**SSD 6010 - One Residential Building (Student Accommodation) within
Darling Drive Plot**

Submission by:

26 July 2013

SICEEP - SSDA3 Shadow Study

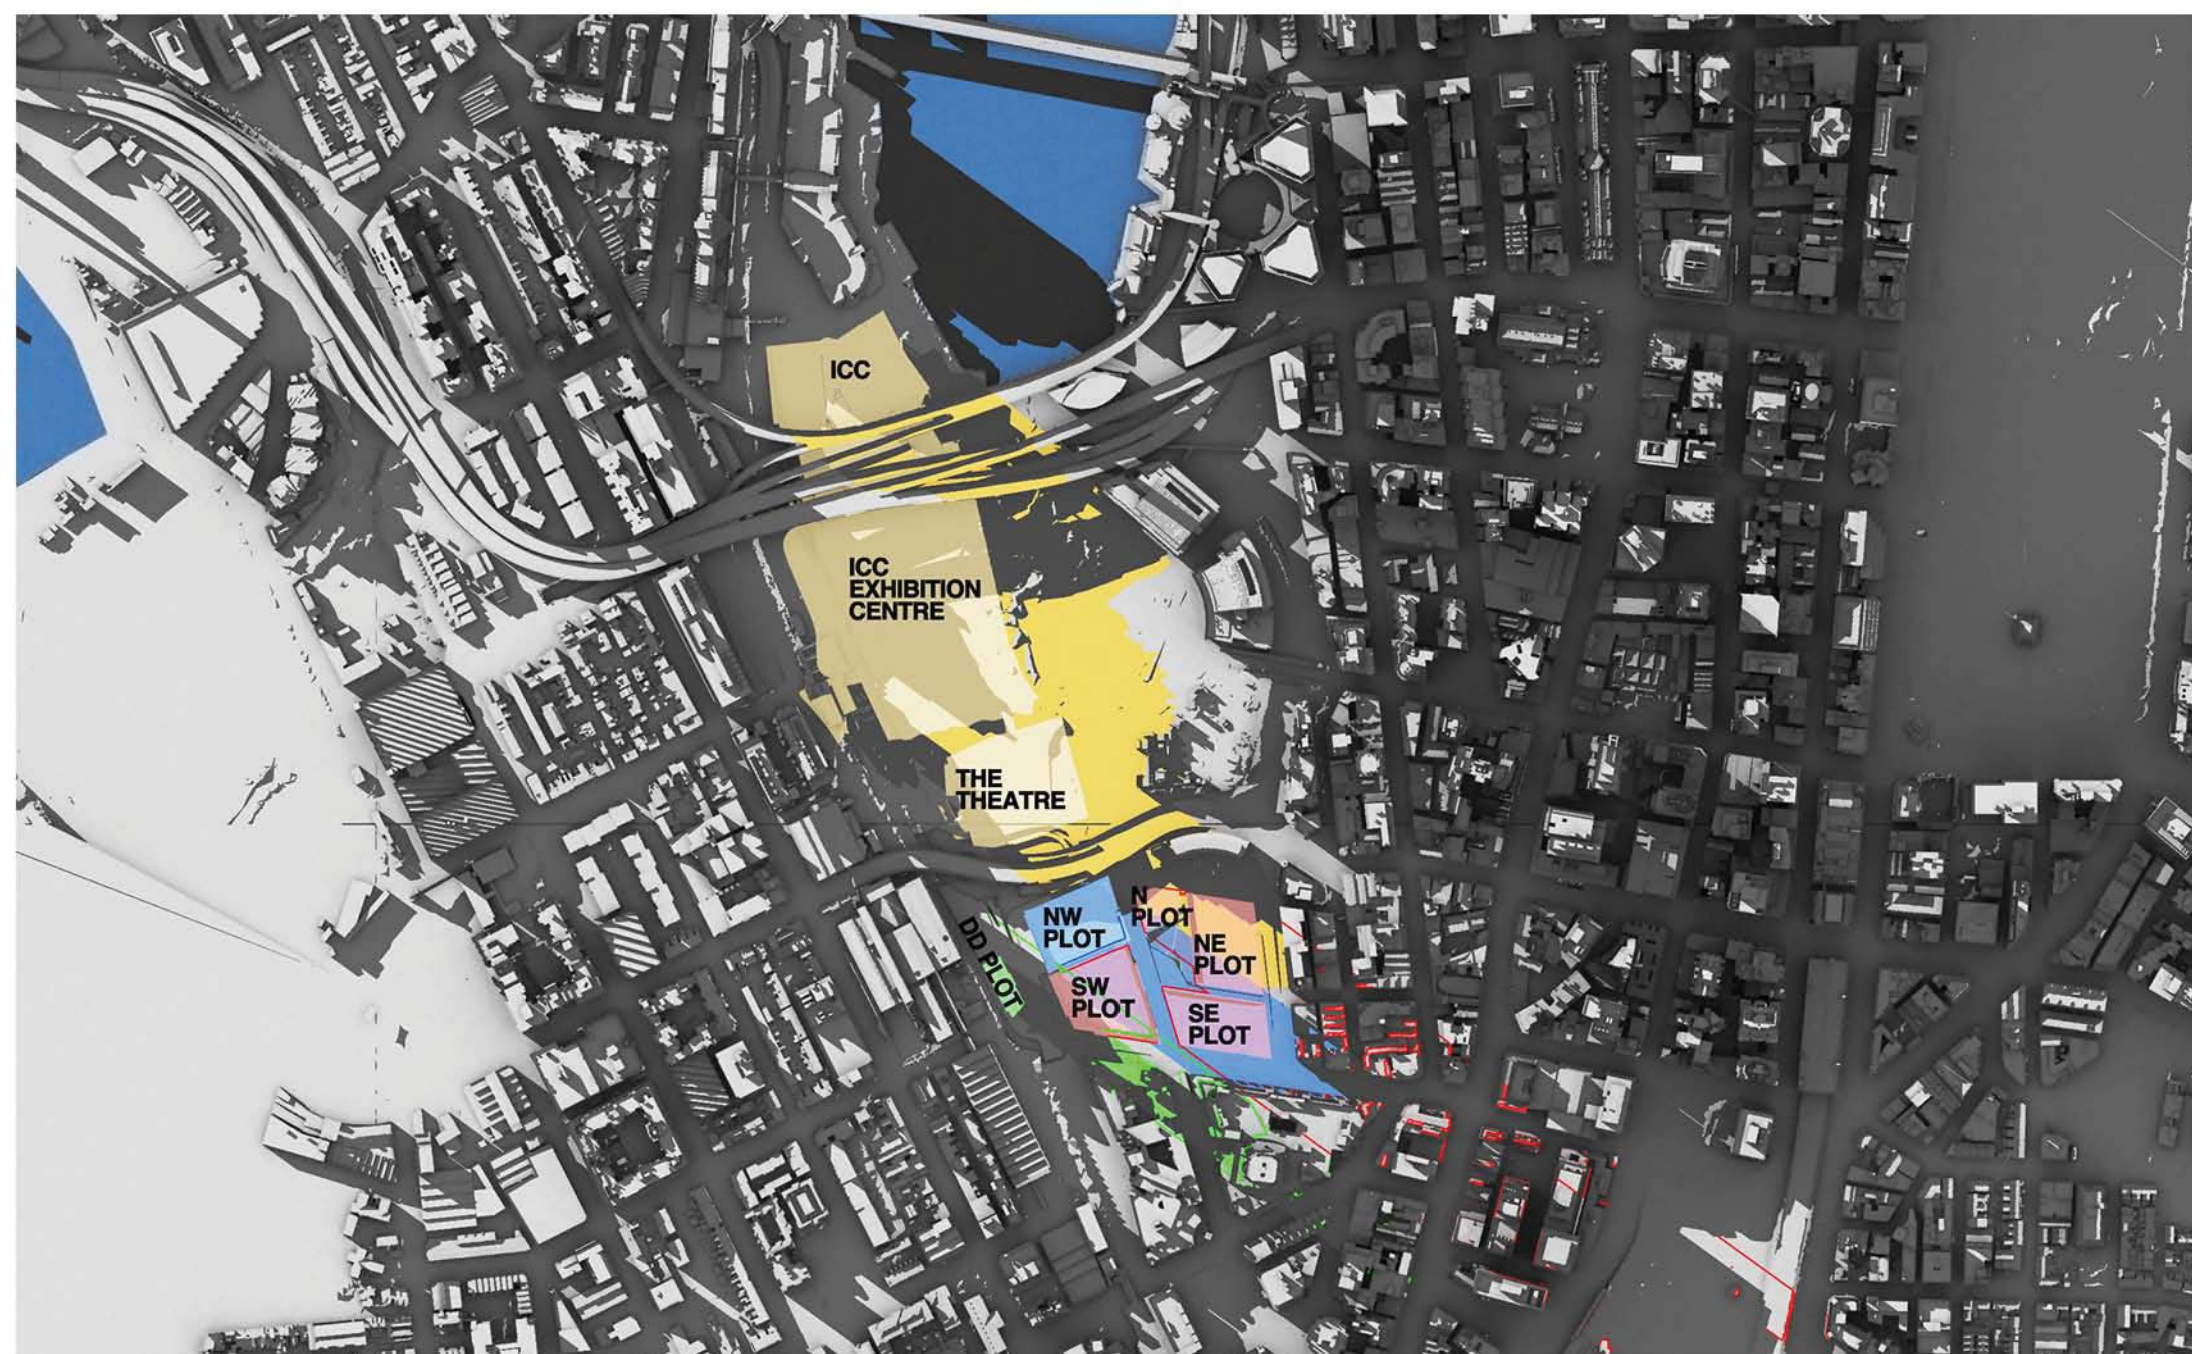
Proponent statement	Location of statement	Actual fact
<i>At mid-winter (22 June) there is some additional overshadowing impact to the Markey City podium and to the western elevation of The Peak Apartments after 2 pm. There is no additional overshadowing during the morning period, or the early afternoon.</i>	SSD5878 Response to Submissions and Amendments to Proposed Development Report, July 2013, Section 2.8 Overshadowing	That statement is misleading; in fact the podium additional overshadowing starts at 9 am and increases throughout the morning and early afternoon.
<i>At mid-winter (22 June) By 4pm, approximately 45-50% of the western elevation is in shadow, however the shadow has substantially moved off the northern façade such that only approximately 15-20% of the façade remains in shadow.</i>	SSD5878 Response to Submissions and Amendments to Proposed Development Report, July 2013, Section 2.8 Overshadowing	That statement is false, as can be seen from the diagram. The proponent has confused the western and northern facades.

Proponent statement	Location of statement	Actual fact
Winter solstice - 22 June <i>9:00 - 1.00 NO IMPACT</i>	SSD5878 Appendix H. Supplementary Design Report, Section 6. Amendments Winter solstice - 22 June	That statement is false; in fact the podium roof additional overshadowing starts at 9 am and increases throughout the 9 am to 1 pm period (and continues to increase thereafter)
Winter solstice - 22 June <i>2:00 – The western edge of the Market City podium roof is overshadowed</i>	SSD5878 Appendix H. Supplementary Design Report, Section 6. Amendments Winter solstice - 22 June	Most of the western and northern podium roof is overshadowed.
Winter solstice - 22 June <i>3:00 – The Market City podium roof is overshadowed from the north west corner to the Peak Tower;</i>	SSD5878 Appendix H. Supplementary Design Report, Section 6. Amendments Winter solstice - 22 June	Almost the entire podium roof is overshadowed.

Winter solstice - 22 June <i>4:00 – The Market City podium roof is overshadowed from the north west corner to the in front of the north elevation of the Peak Tower;</i>	SSD5878 Appendix H. Supplementary Design Report, Section 6. Amendments Winter solstice - 22 June	True, and this has substantially been the case since 2pm.
Winter solstice - 22 June <i>4:00 – 15-20% of the Peak Tower northern elevation remains in shadow since 3pm;</i>	SSD5878 Appendix H. Supplementary Design Report, Section 6. Amendments Winter solstice - 22 June	Actually 45-50% of the Peak Tower northern elevation remains in shadow since 3pm.
Winter solstice - 22 June <i>4:00 – A portion of the Peak Tower north elevation (15-20%) now receives direct sunlight when compared to the maximum building envelope model – portions of which were previously overshadowed at 3pm.</i>	SSD5878 Appendix H. Supplementary Design Report, Section 6. Amendments Winter solstice - 22 June	The reduction compared with the maximum building envelope model can be seen from the diagram to be only about 5-10%.

SHADOW DIAGRAMS: PERSPECTIVE, SHOWING THE PEAK, WINTER SOLSTICE

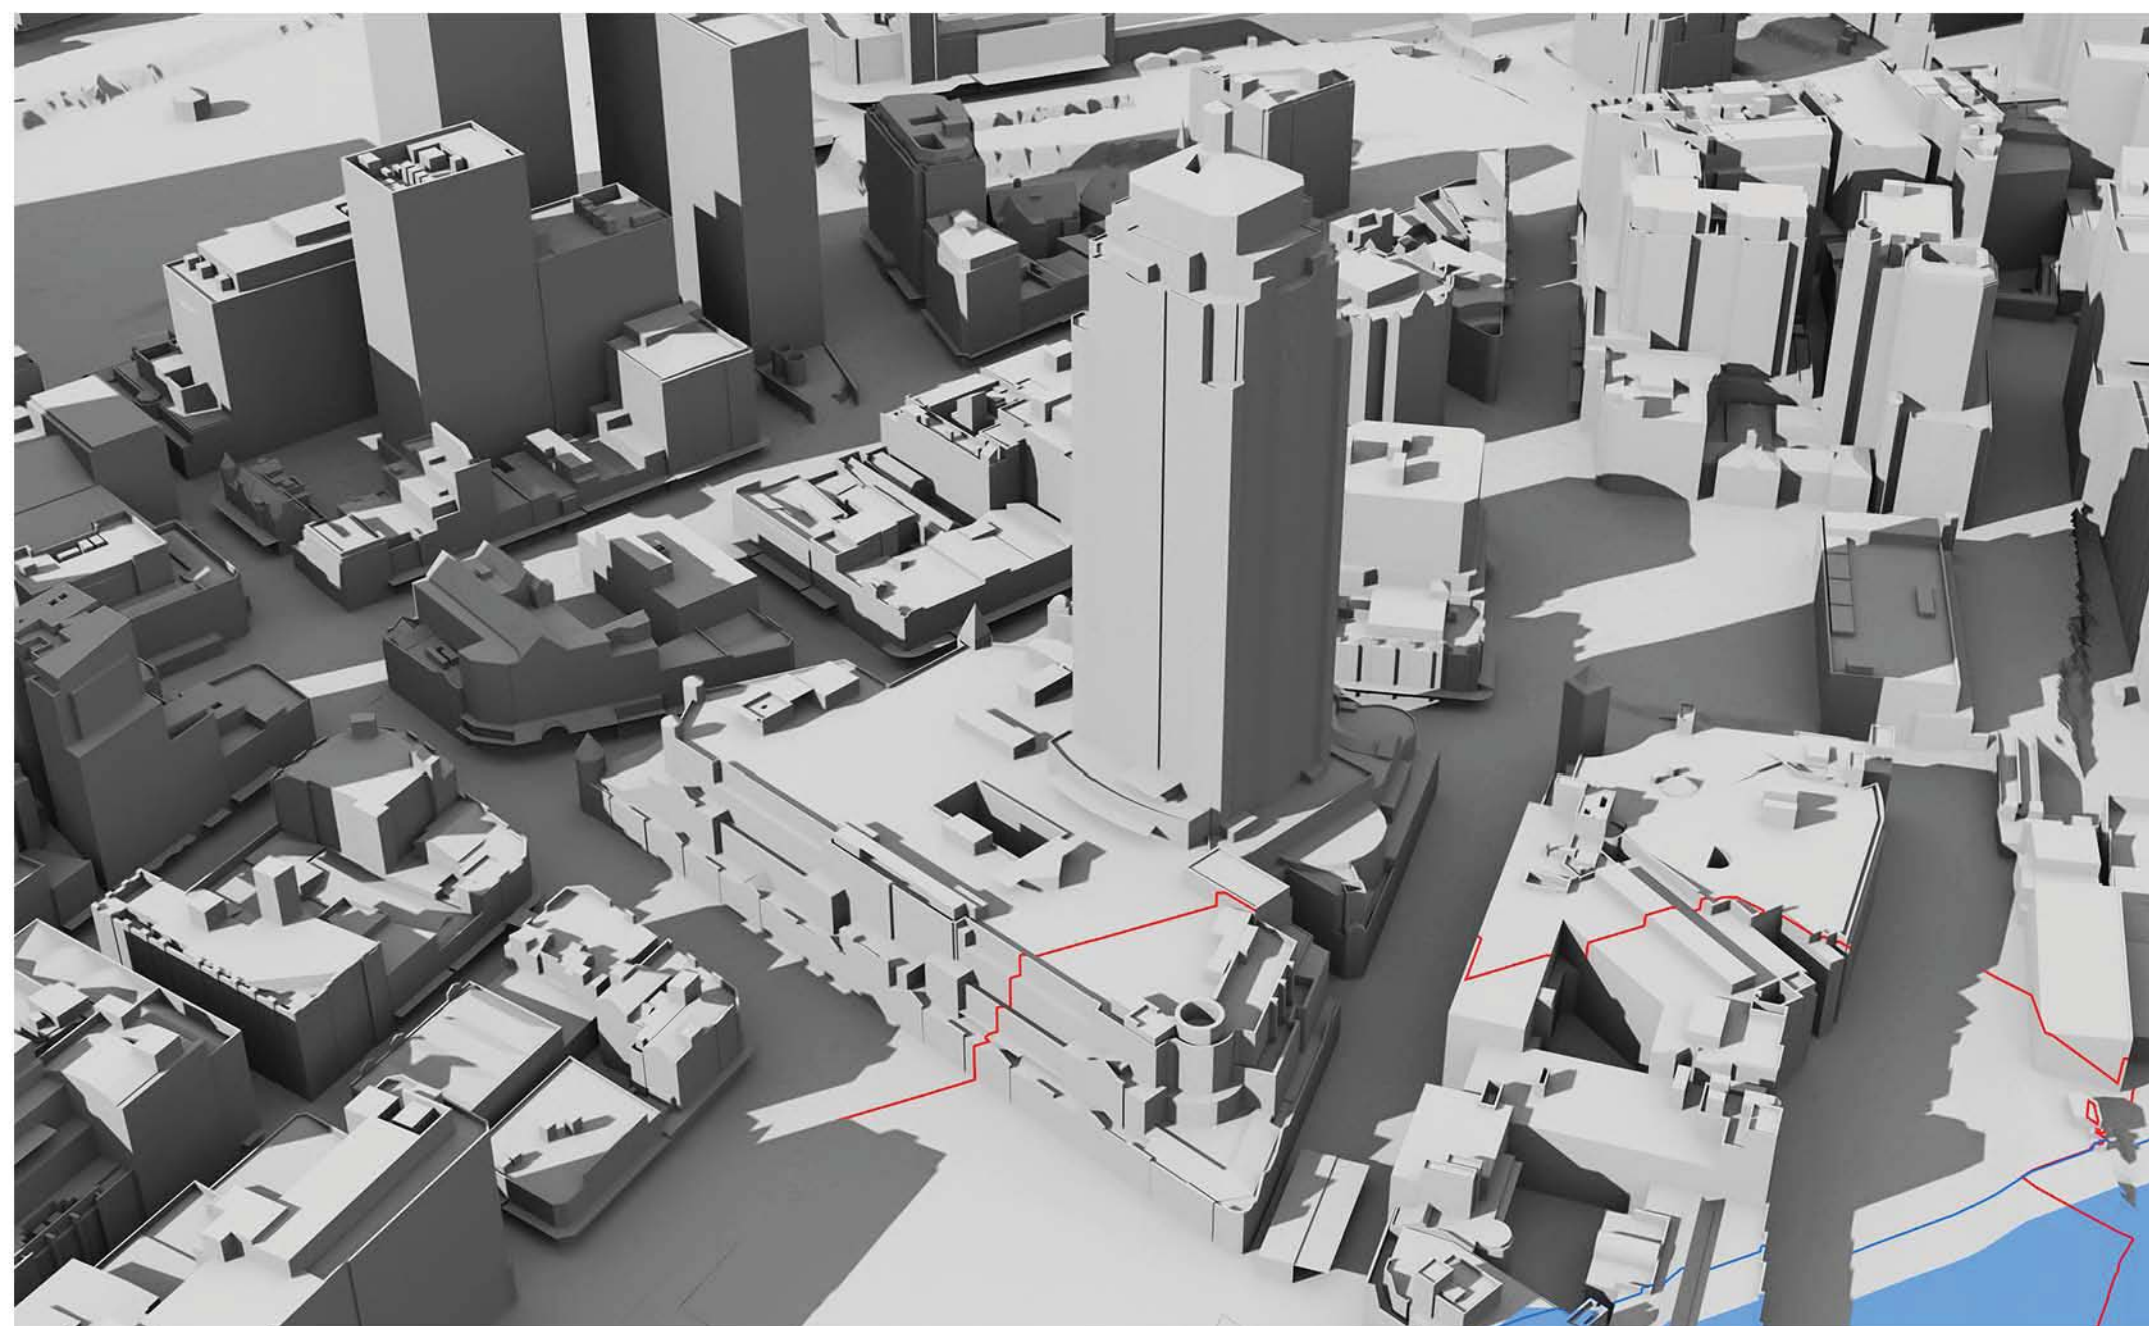
At 9am, 10am and 11am the west façade is totally in shadow due to other parts of The Peak building itself.

At 12pm there is still substantial existing shadowing on the west façade caused by the irregular shape of the west facade.

At 9am, 10am and 11am the west façade is totally in shadow due to other parts of The Peak building itself.

At 12pm there is still substantial existing shadowing on the west façade caused by the irregular shape of the west facade.

At 1pm the existing shadowing has been substantially, although not entirely, removed. However, overshadowing of lower levels of the west façade by the concept proposal parameter plan shadows for the N,NE and SE plots has already started.

By 2pm the existing shadowing has been totally removed. However, overshadowing of the west façade by the SSDA4 and SSDA5 buildings has appeared and risen further up the west façade than the concept proposal parameter plan shadows for the N,NE and SE plots, which is still present.

It can be concluded that, as a result of combination of the proposed development with existing shadowing of the west façade, some single aspect apartments on the west façade and the south-west dual aspect corner apartments which currently receive less than 2 hours direct sunlight to habitable rooms and 50% of the private open space between 9am and 3pm on 21 June will suffer additional overshadowing. It is beyond our skills to count the number of such apartments. We note that the proponent has made no attempt to do so.
